**RE: Major Project MP 08_0116 - Potts Hill Residential Estate – Civil Works Stage 2
Section 75W Modification No. 2**

This letter and attachments form an Environmental Assessment to support a Section 75W Modification to the abovementioned Major Project Approval. Under Section 75W of the *Environmental Planning and Assessment Act 1979 (EP&A Act)*, we seek approval to modify Condition A2 of the Project Application Consent MP08_0116 (as modified) to amend the number and type of lots, consolidate a number of lots to accommodate moderate income housing, amend the boundaries between Stages 1, 2 and 3, amend the size of a number of lots and amend the Conditions of Approval to reflect these changes.

LANDCOM	SHEET 1 OF 2	
	DATE: 12th NOVEMBER 2009	Rev
PLAN OF PROPOSED STAGE 1 SUBDIVISION OF PROPOSED LOT 106 IN A PROPOSED SUBDIVISION AT COOPER ROAD, POTTS HILL . G. A. BANKSTOWN	DRAWING No: 600246 SA-101	B

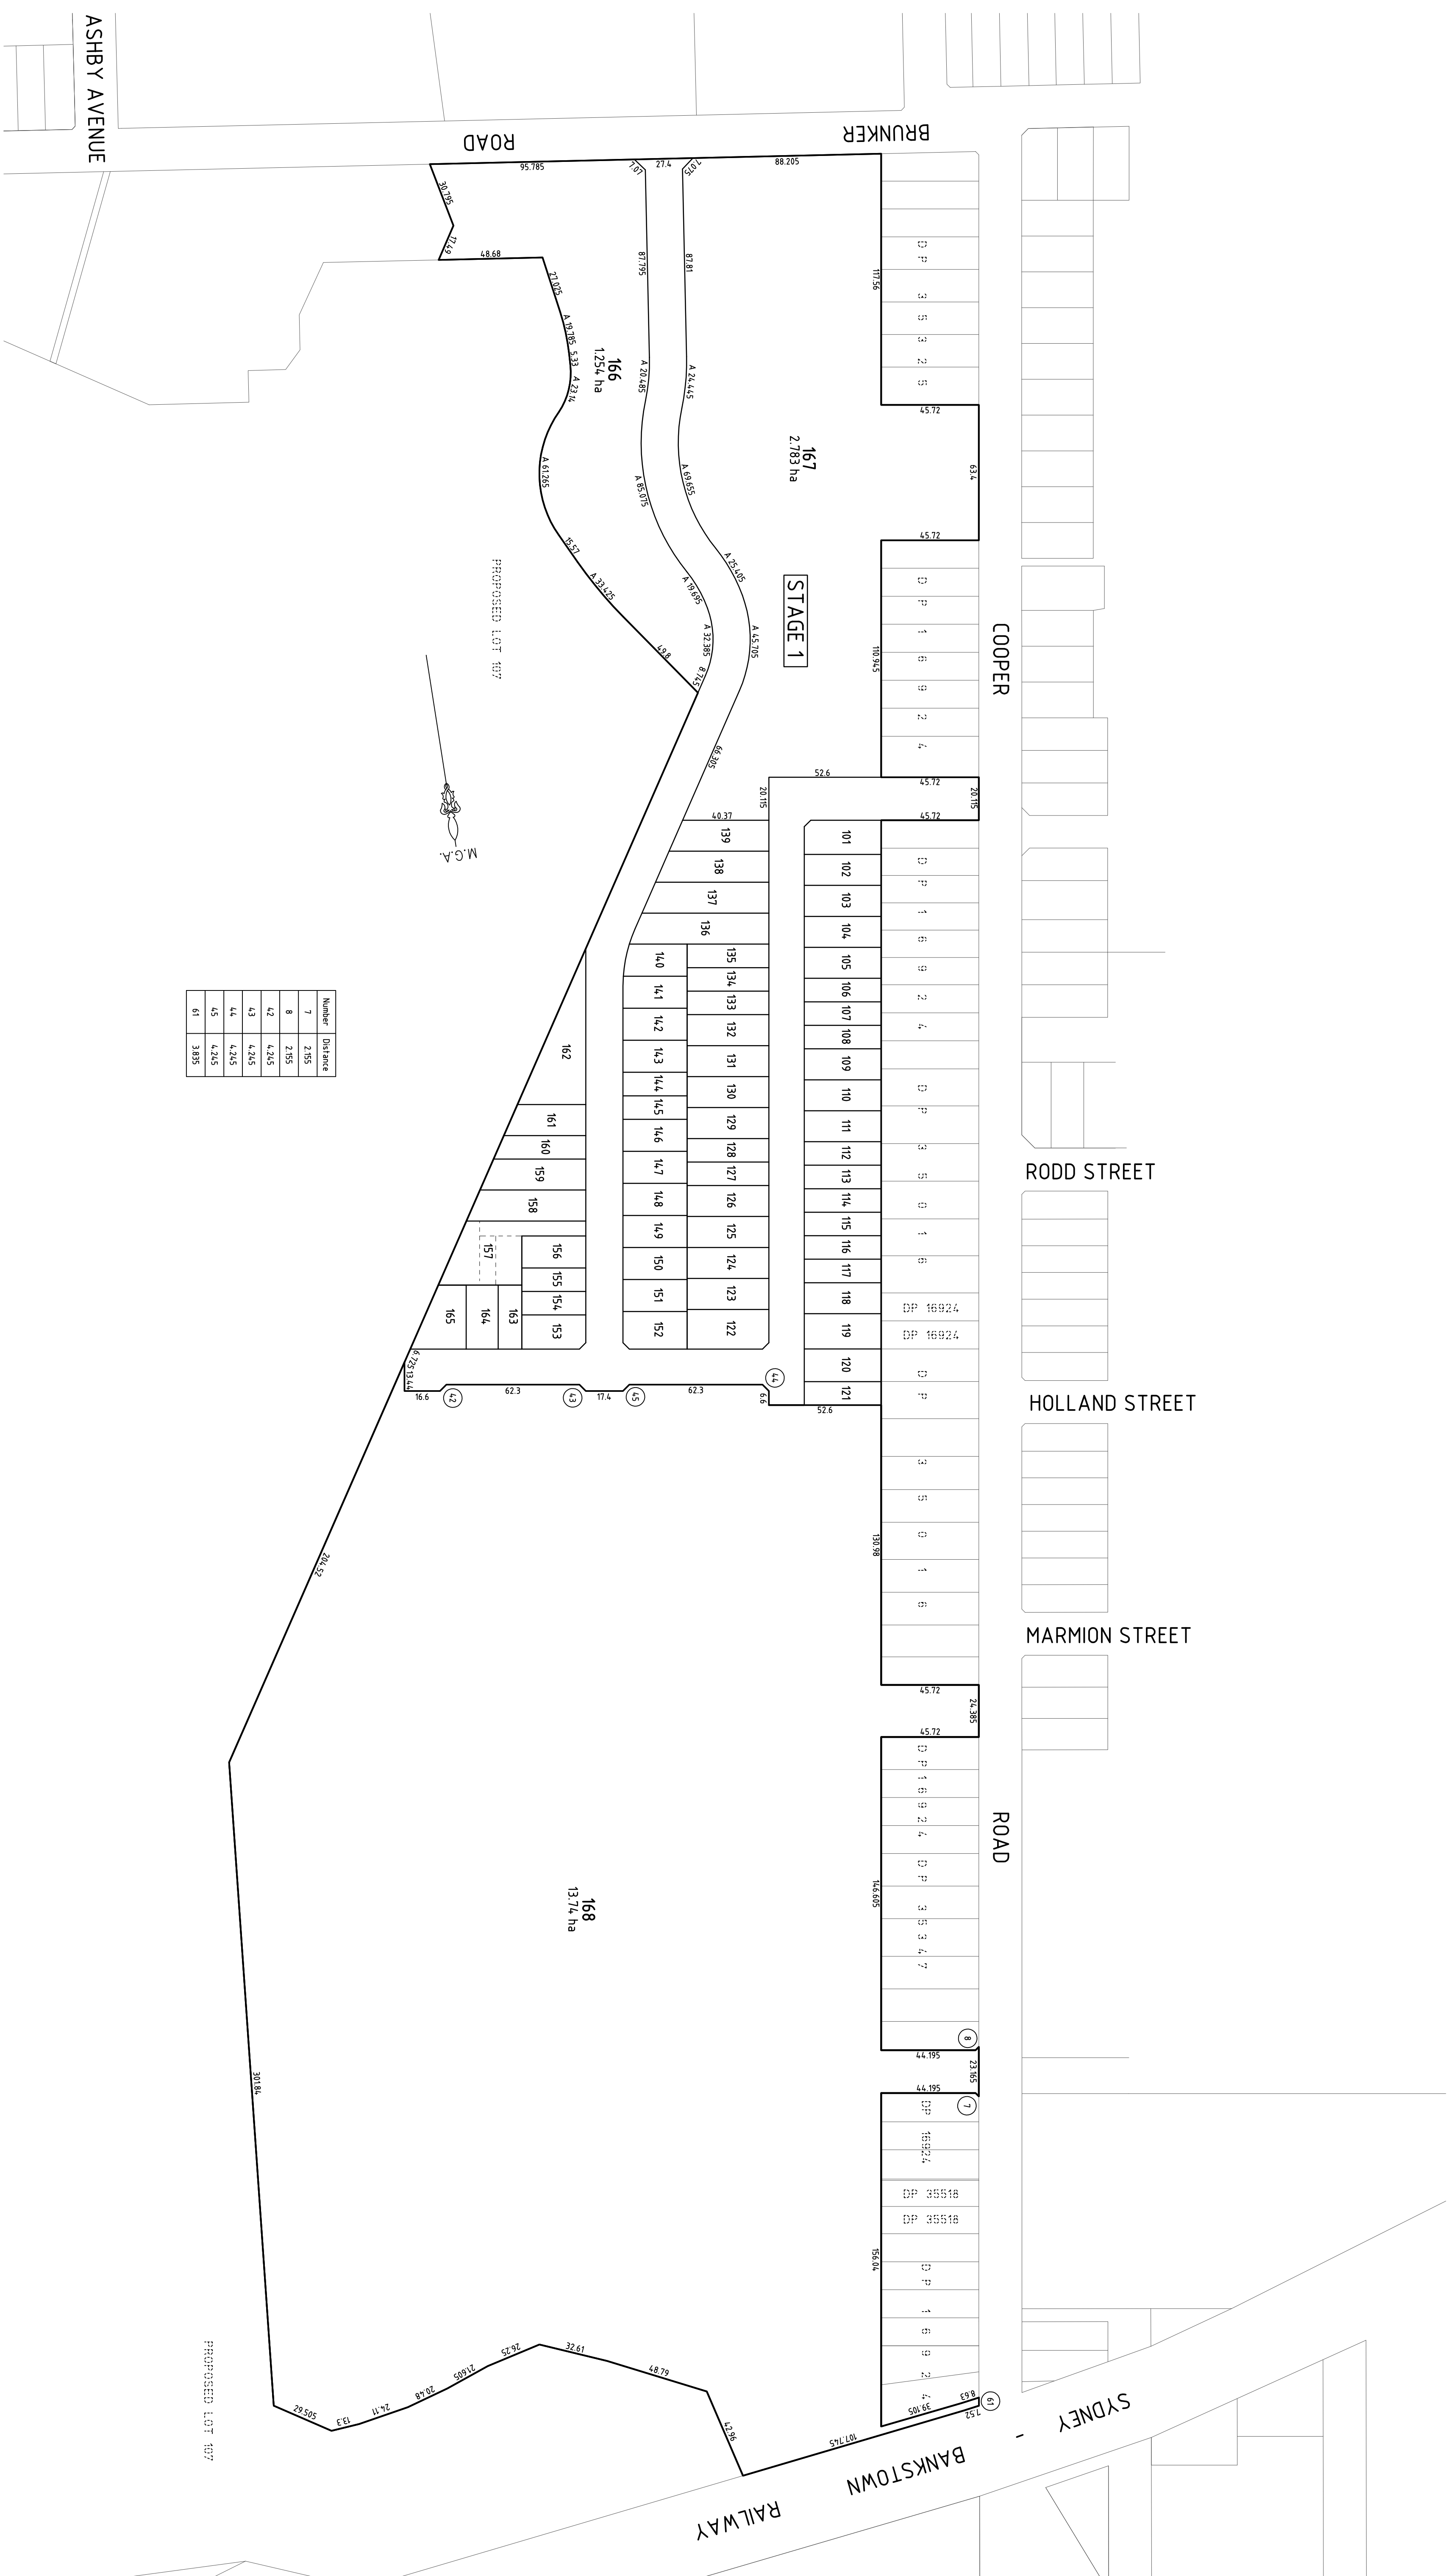
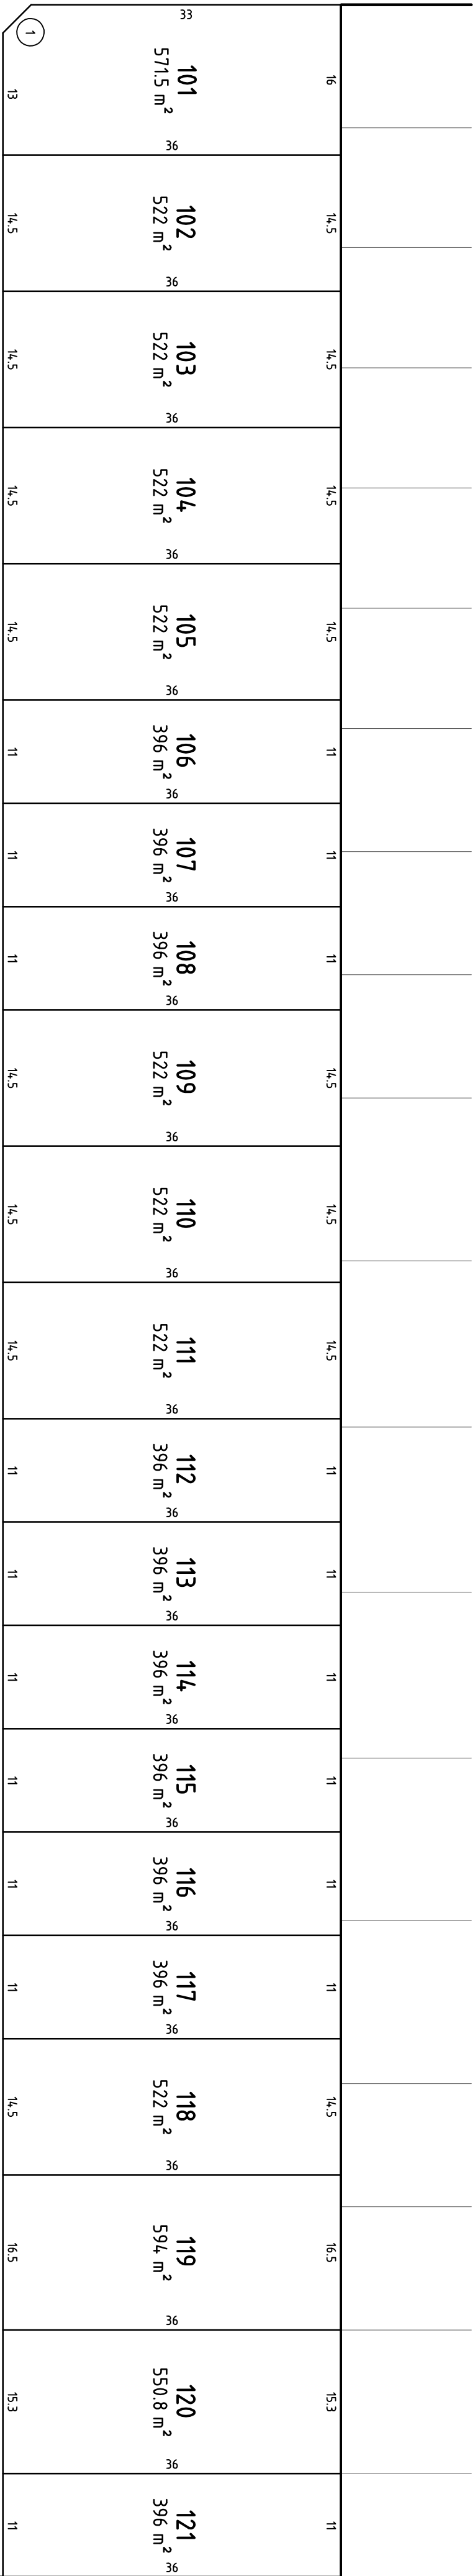
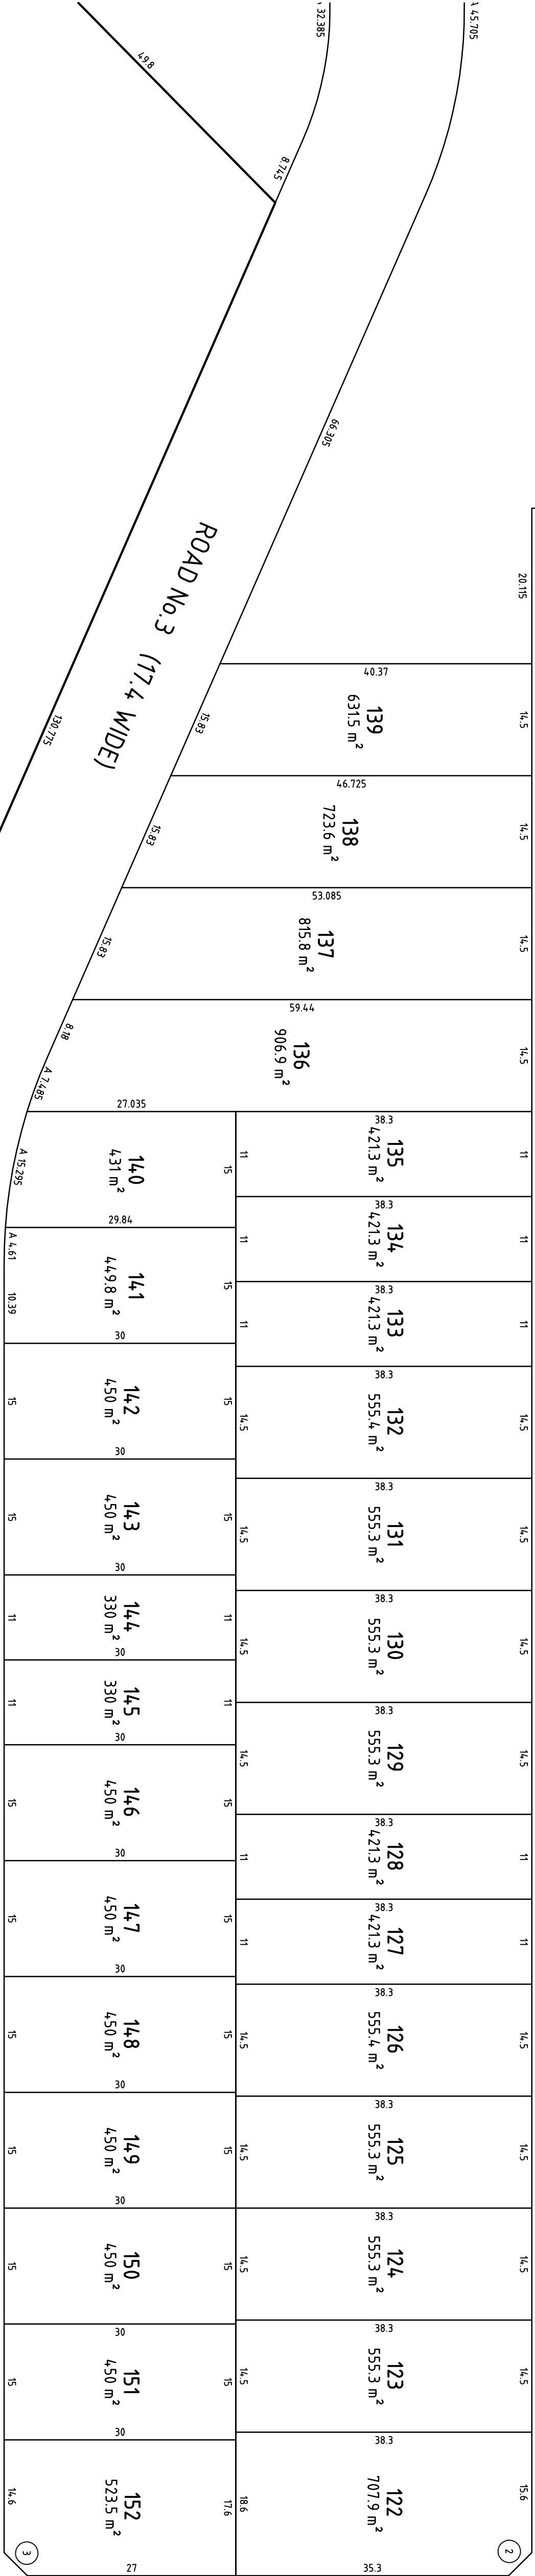
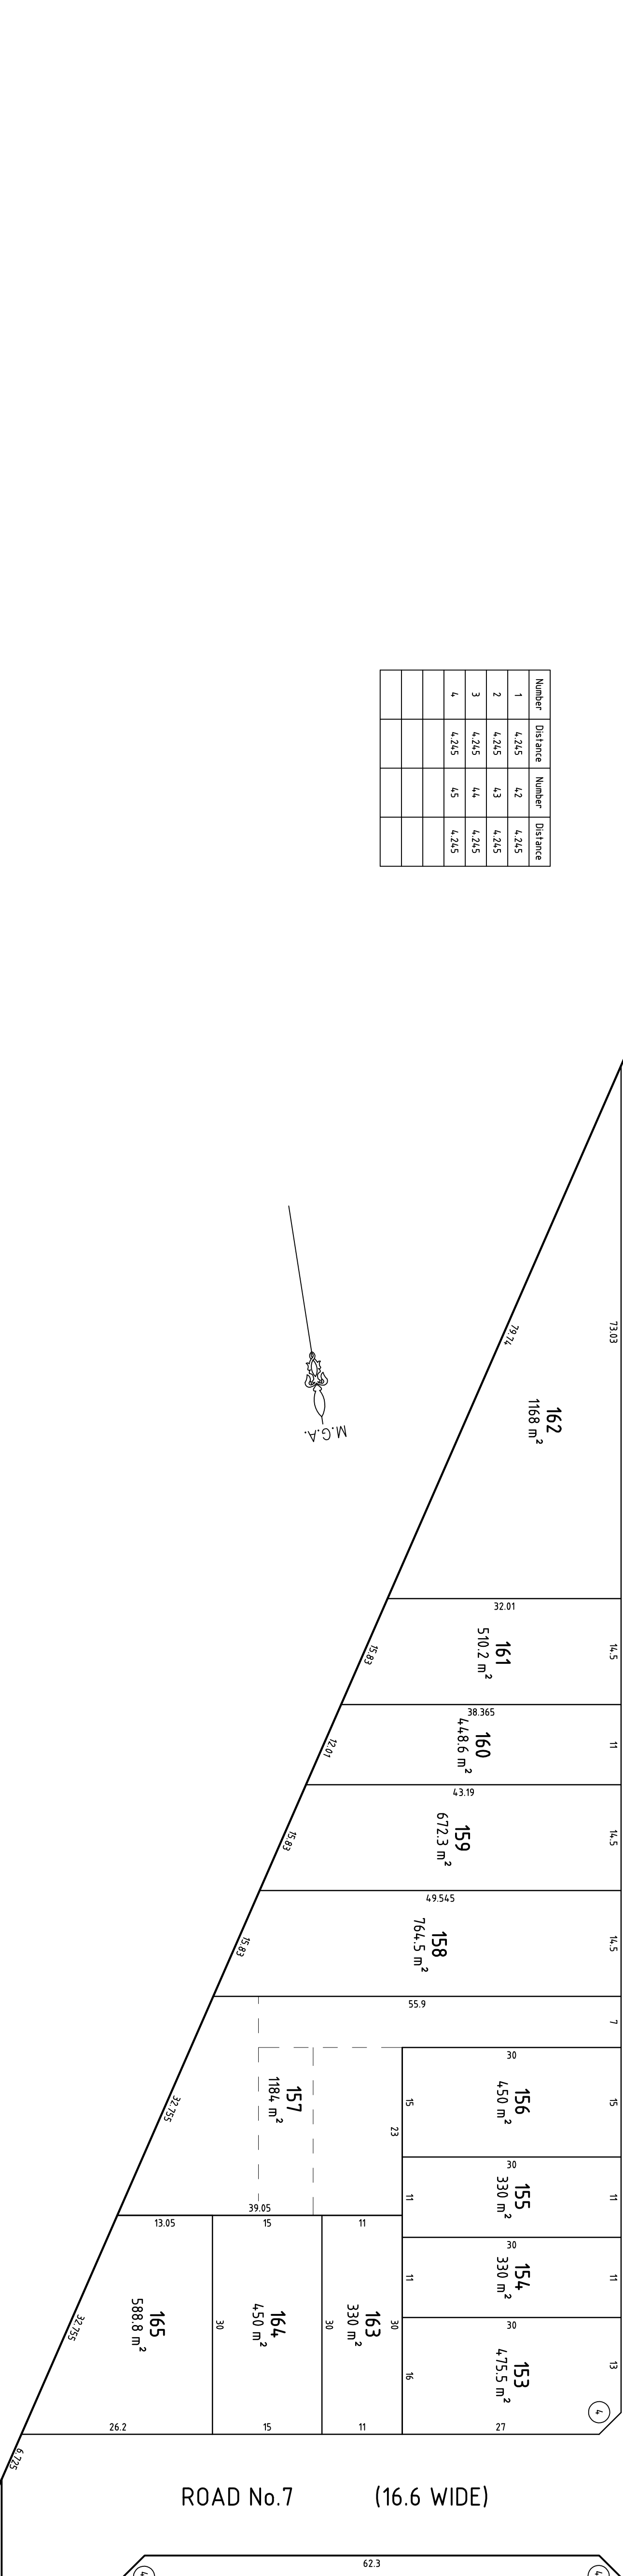
- Approved Lot 256 to 258 are to be consolidated into one new lot (proposed Lot 166); and
- Approved Lots 165 and 166 are to be consolidated into one new lot (proposed Lot 165);

The approved subdivision plan provides a road width of 17.4 metres, which is inconsistent with the approved Civil Engineering Plans, with an approved road width of 17 metres. The proposed lot size modifications are detailed at **Table 2**.

Approved Lot Number (MP 08_0116)	Proposed Lot Number (Concept Plan MP 08_0116 MOD 2)	Approved Lot Area (Concept Plan MP 08_0116)	Proposed Lot Area (Concept Plan MP 08_0116 MOD 2)	Justification
Lot 153	Lot 153	475.5m ²	478.7m ²	Readjustment of lot size as adjacent Road 3 width adjusted to match approved Civil Engineering Drawings.
Lot 154	Lot 154	330m ²	332.2m ²	Readjustment of lot size as adjacent Road 3 width adjusted to match approved Civil Engineering Drawings.

Approved Lot Number (MP 08_0116)	Proposed Lot Number (Concept Plan MP 08_0116 MOD 2)	Approved Lot Area (Concept Plan MP 08_0116)	Proposed Lot Area (Concept Plan MP 08_0116 MOD 2)	Justification
Lot 155	Lot 155	330m ²	332.2m ²	Readjustment of lot size as adjacent Road 3 width adjusted to match approved Civil Engineering Drawings.
Lot 156	Lot 156	450m ²	453m ²	Readjustment of lot size as adjacent Road 3 width adjusted to match approved Civil Engineering Drawings.
Lot 157	Lot 157	1,184m ²	1,185m ²	Readjustment of lot size as adjacent Road 3 width adjusted to match approved Civil Engineering Drawings.
Lot 158	Lot 158	764.5m ²	767.4m ²	Readjustment of lot size as adjacent Road 3 width adjusted to match approved Civil Engineering Drawings.
Lot 159	Lot 159	672.3m ²	675.2m ²	Readjustment of lot size as adjacent Road 3 width adjusted to match approved Civil Engineering Drawings.
Lot 160	Lot 160	448.6m ²	450.8m ²	Readjustment of lot size as adjacent Road 3 width adjusted to match approved Civil Engineering Drawings.

Lot 161	Lot 161	510.2m ²	513.1m ²	Readjustment of lot size as adjacent Road 3 width adjusted to match approved Civil Engineering Drawings.
Lot 165	Lot 165	370.5m ²	588.8m ² .	Amalgamation of these lots will allow for practical residential development on this land. The approved lot configuration is not considered to facilitate a practical development outcome, given the irregular shape of the allotment.
Lot 166		218.3m ²
